CITY OF ALBUQUERQUE

Re: PEERLESS TIRES
241 Eubank Blvd. NE
Approval of PERMANENT Certificate of Occupancy (C.O.)
Engineer's Stamp dated 03/06/2006 (K-20/D56)
Certification dated 08/04/2006

**Re: Peerless Tire, 241 Eubank Blvd NE, Grading and Drainage Report
Engineer's Stamp dated 2-16-06 (K20-D56)**

Re: Peerless Tire Company, 241 Eubank NE, Traffic Circulation Layout
Architect's Stamp dated 01-25-06 (K20-D56)

TRAFFIC CIRCULATION LAYOUT

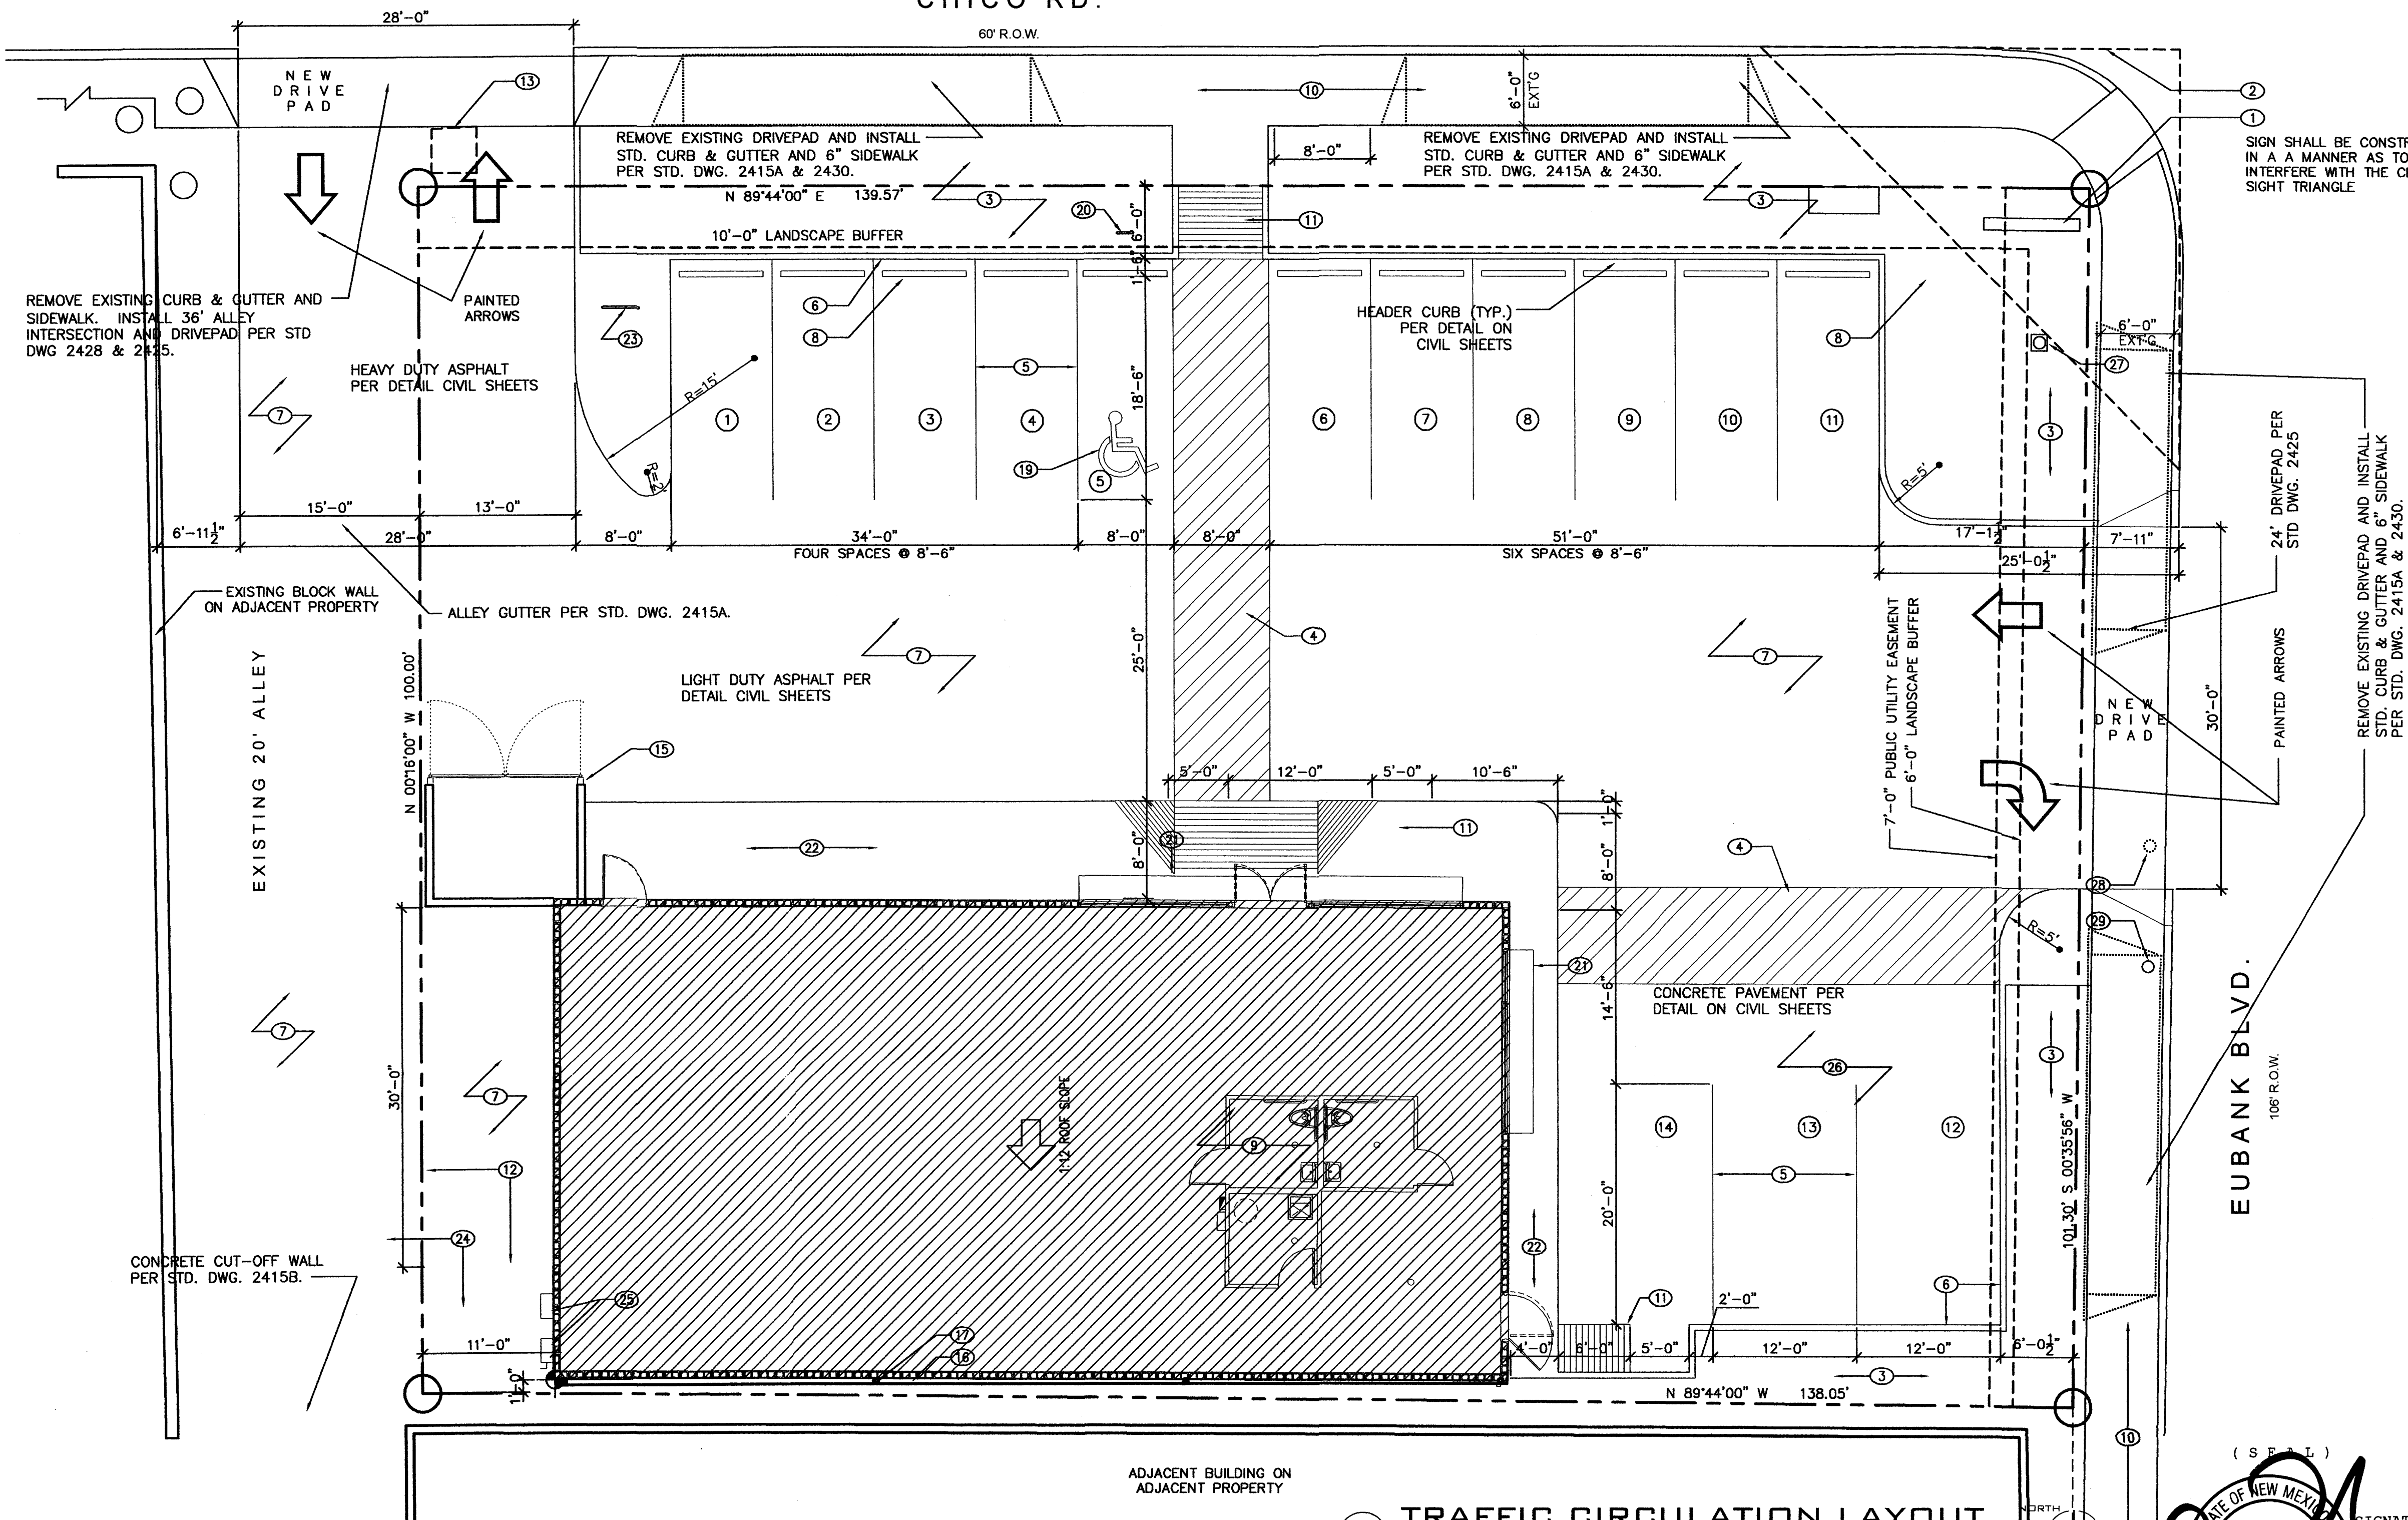
- ✓ 1. List radii for all curves shown.
- ✓ 2. Label the drive-pads as existing or proposed.
- ✓ 3. Please, refer to all appropriate City Standards; the drawing number should be included in this reference.

- ✓ 4. Provide the width for the sidewalk along Chico and Eubank.
- ✓ 5. Show a detail for the wheelchair ramps or refer to the appropriate City Standards. *(Add Note: Build to ADA)*

- ✓ 6. The handicapped parking stall needs to be 8.5' in width with an 8' aisle.
- ✓ 7. Include proof that the future sign, located at Eubank and Chico, will not interfere with the clear sight triangle. *Added Note*

- ✓ 8. Is parking stall #14 a handicapped stall? *No*
9. Provide more information on the entrance to the north and how the alley access will be impacted.

- ✓ 10. Does the east entrance have median access, or is this right in and right out?
- ✓ 11. The east entrance needs to be a minimum of 30' wide. A curb return with a radius of 30' is recommended. Appropriate signing and striping must also be provided. *Move light pole*

12. Define the throat depth off of Eubank.
- ✓ 13. Provide the distance on the NW entrance from alley to curb return.

*Show
exist drivepads
& proposed
removal*

*4' SW ok'd by
Zoning*

SITE GRADING PLAN

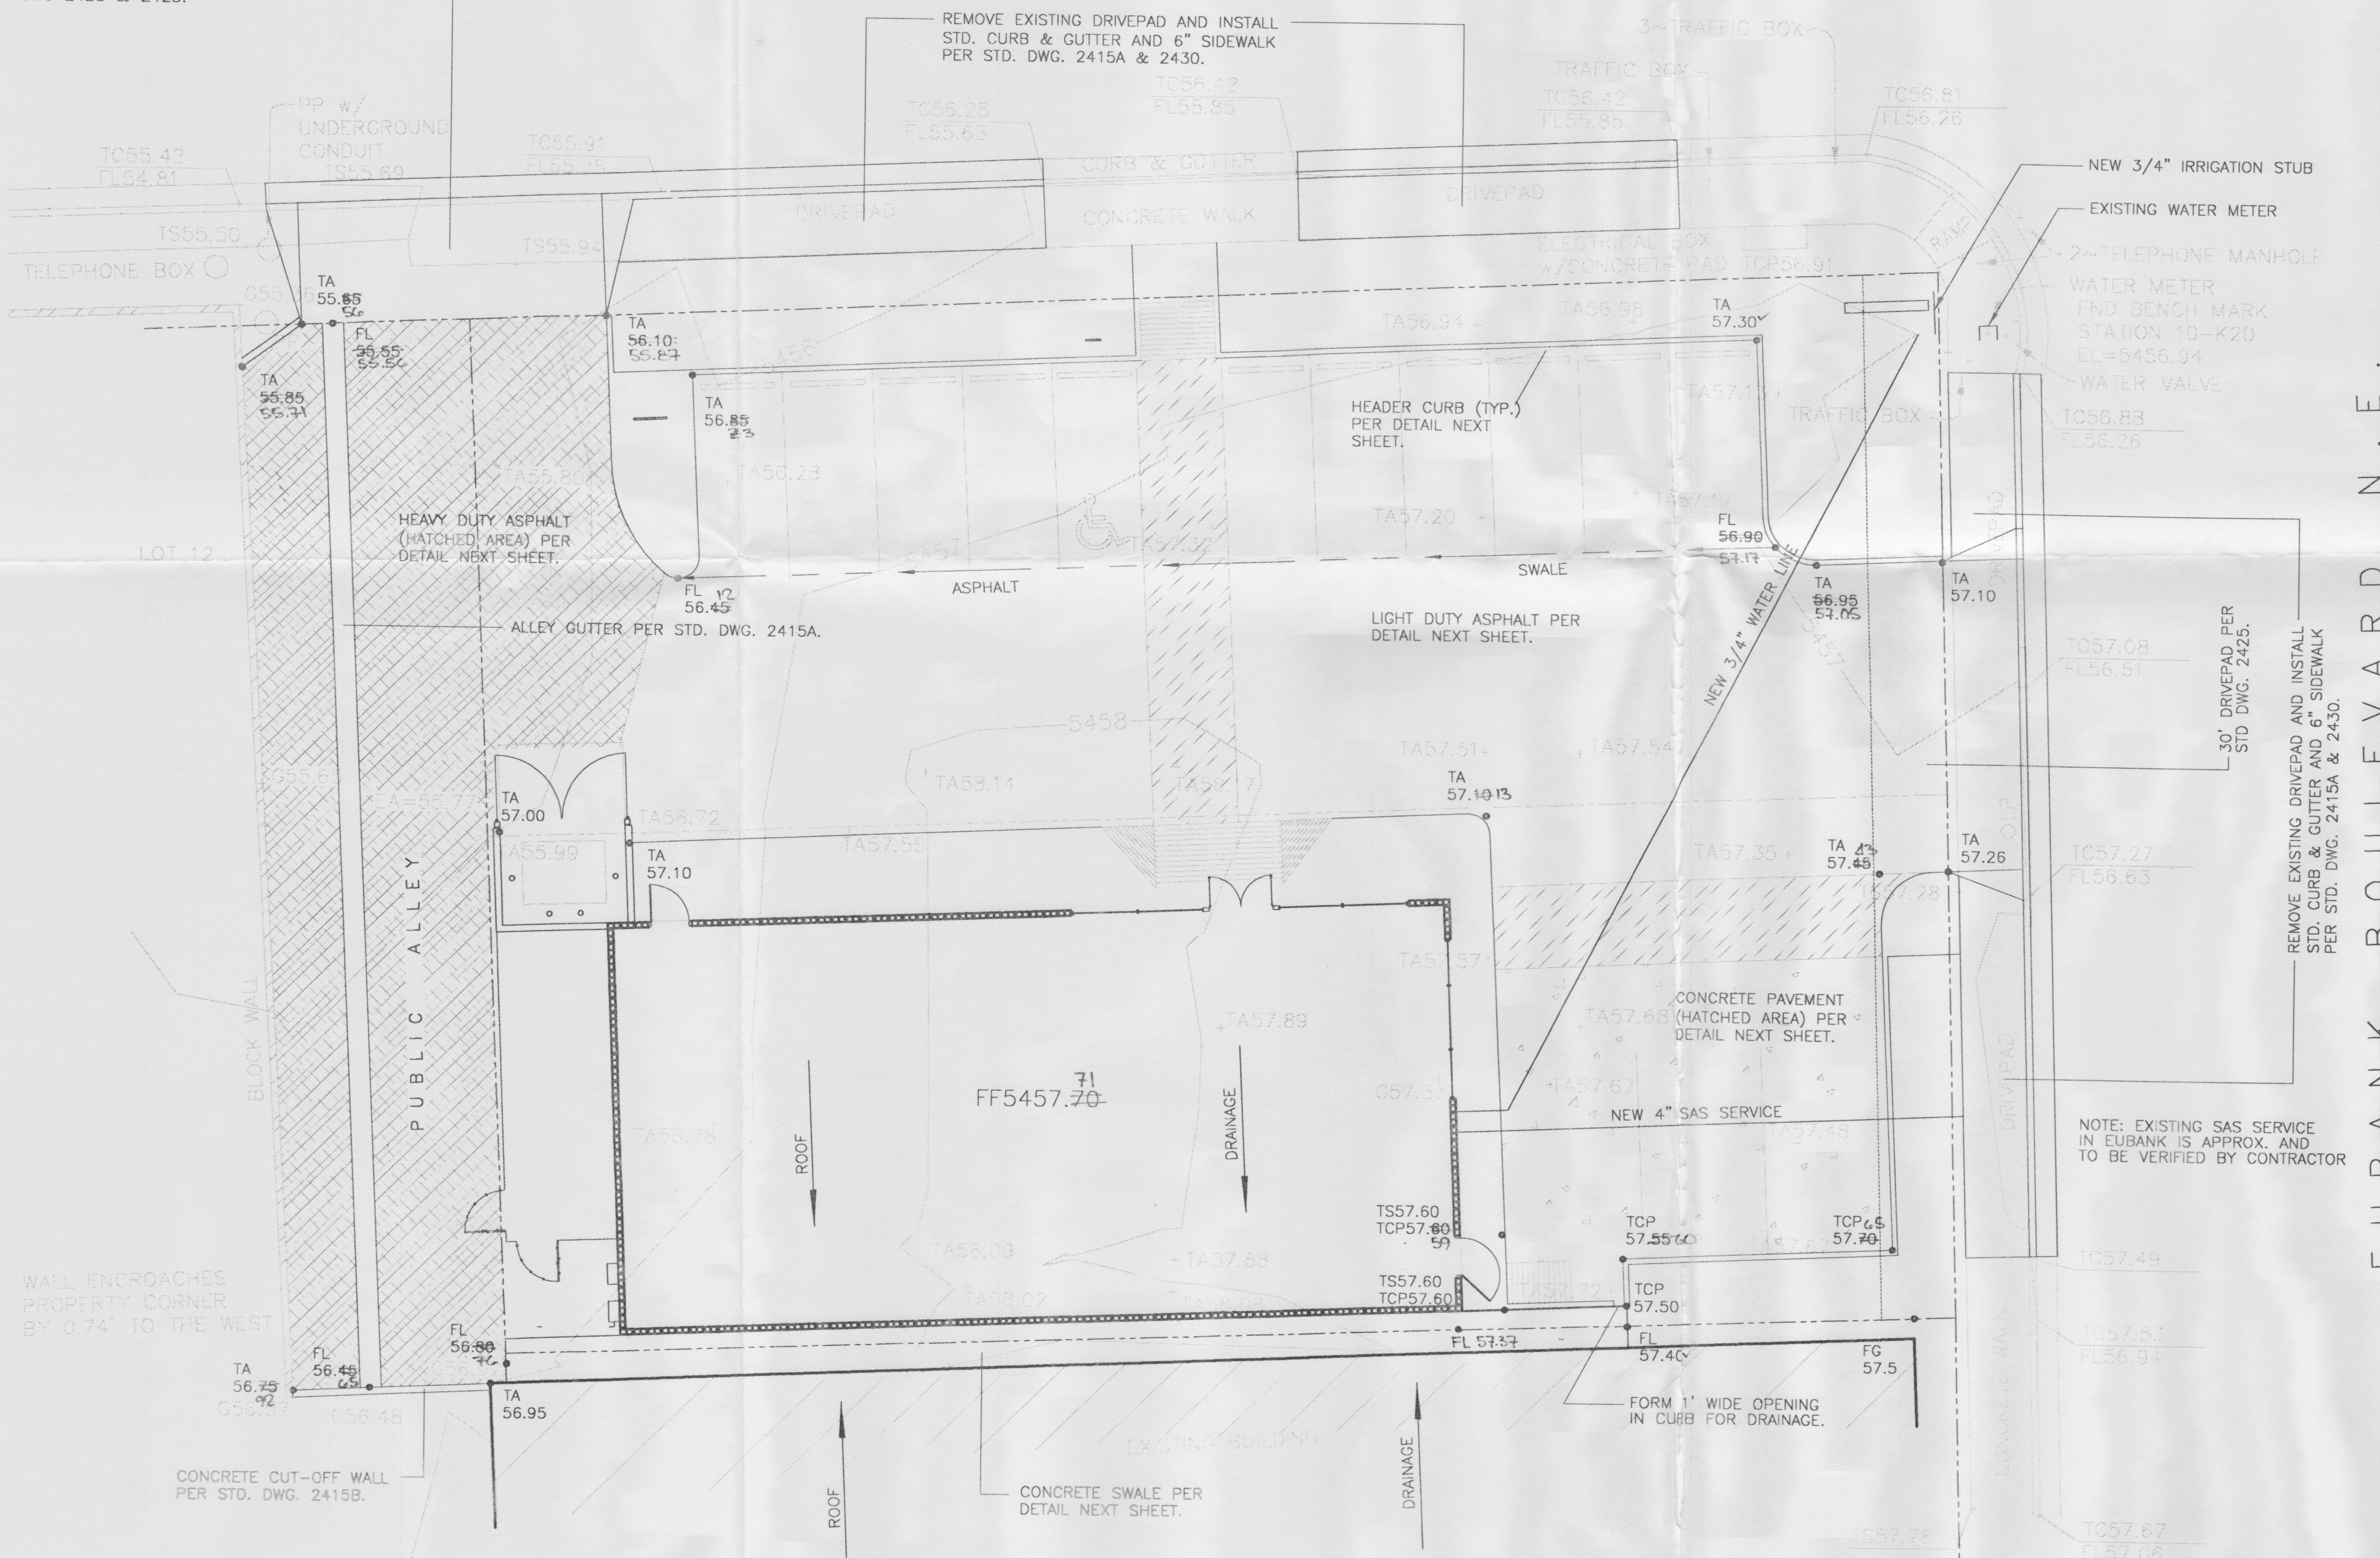
1. Provide a copy of the vee channel detail. Define the amount of flow entering the vee channel from the building to the south.
2. Verify the elevations near the Eubank Boulevard entrance.
3. There appears to be a ponding condition just east of the proposed building. Should there be a curb cut in this area? Please define the quantity of flow entering the channel from this area.
4. Please stamp, sign, and date the report/calculations.
